Planing Ref: **R/190/13**

Re: Land to the rear of 20 & 22 Broadmark Lane, Rustington.

I would like to object to the proposed application for a large detached dwelling at the above location.

PROPOSED STREET (SOUTH) ELEVATION (1:200)

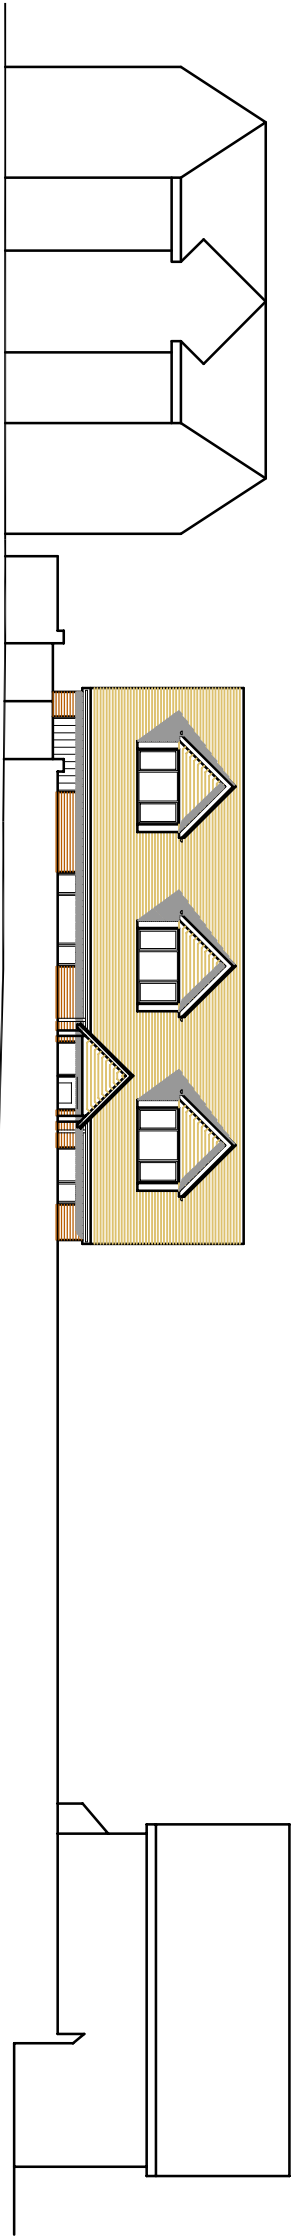
This proposal would affect the overall street scene and have a detrimental and imposing affect to many houses in the immediate area of Broadway Way in addition to those sited on Broadmark Lane as well as houses and garden outlook of those sited in Knightscroft Avenue.

DRAWING TITLE
SITE LOCATION AND LAYOUT PLANS

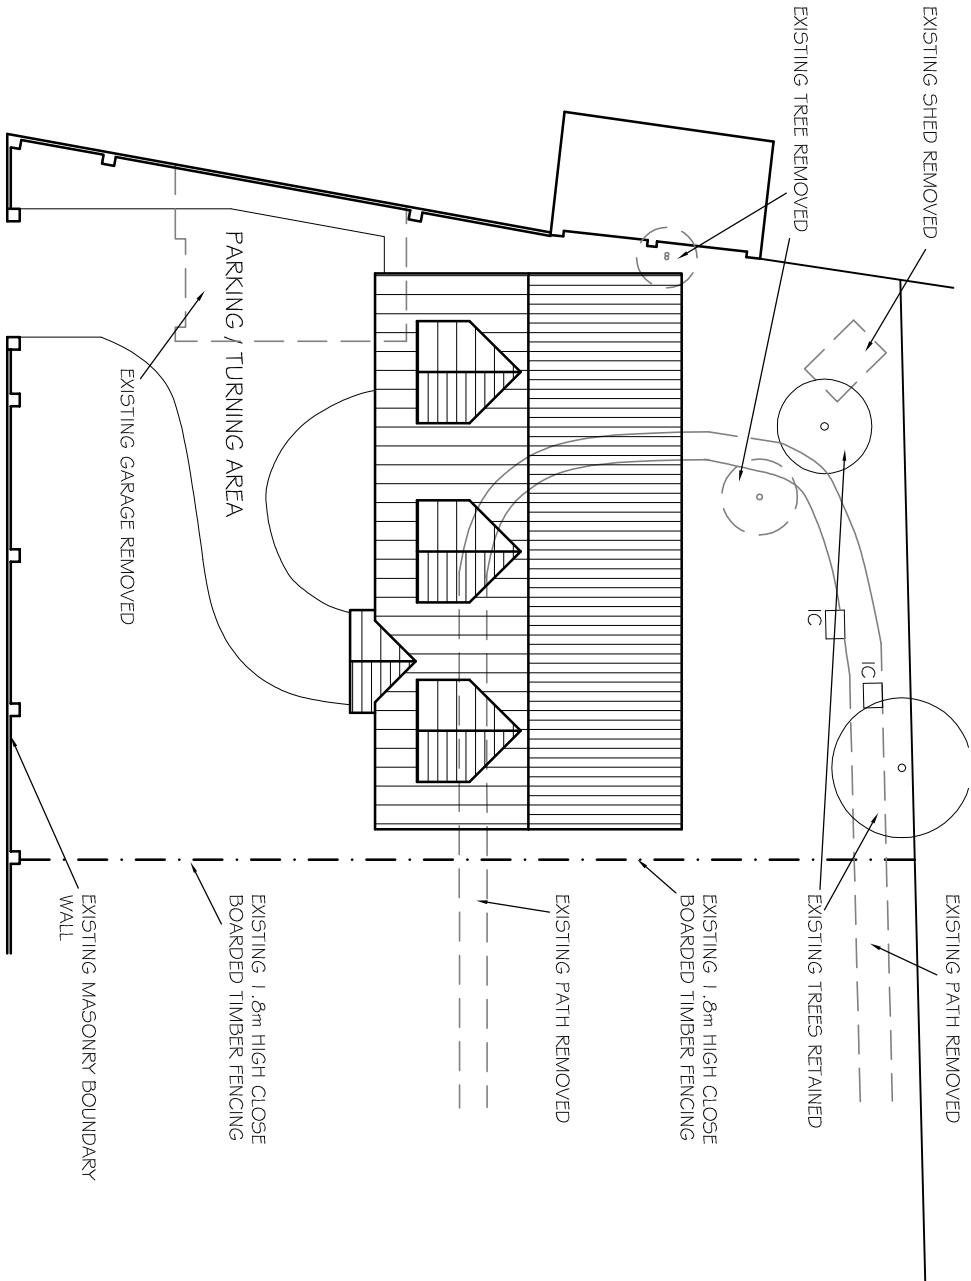
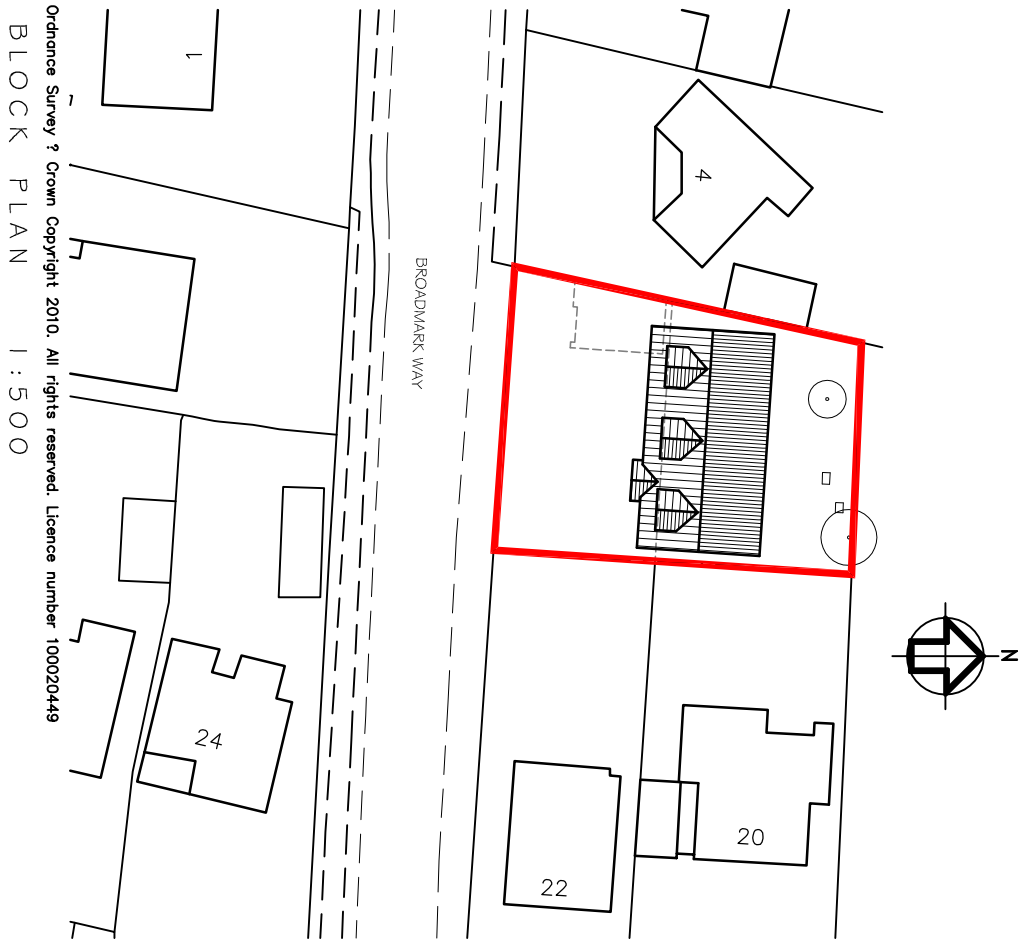
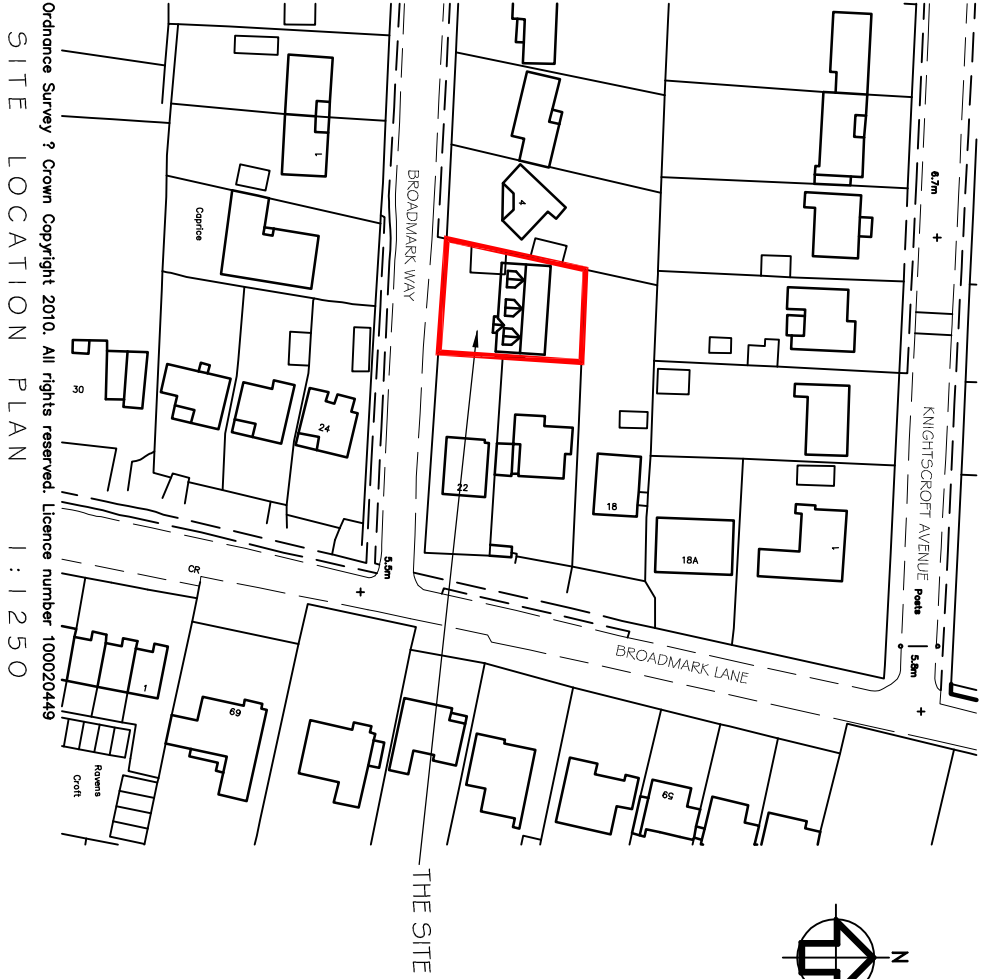
The proposal is far to large for the site and would result in an unduly cramped and contrived form of development which would be detrimental to the character and amenities of the surrounding residential area.
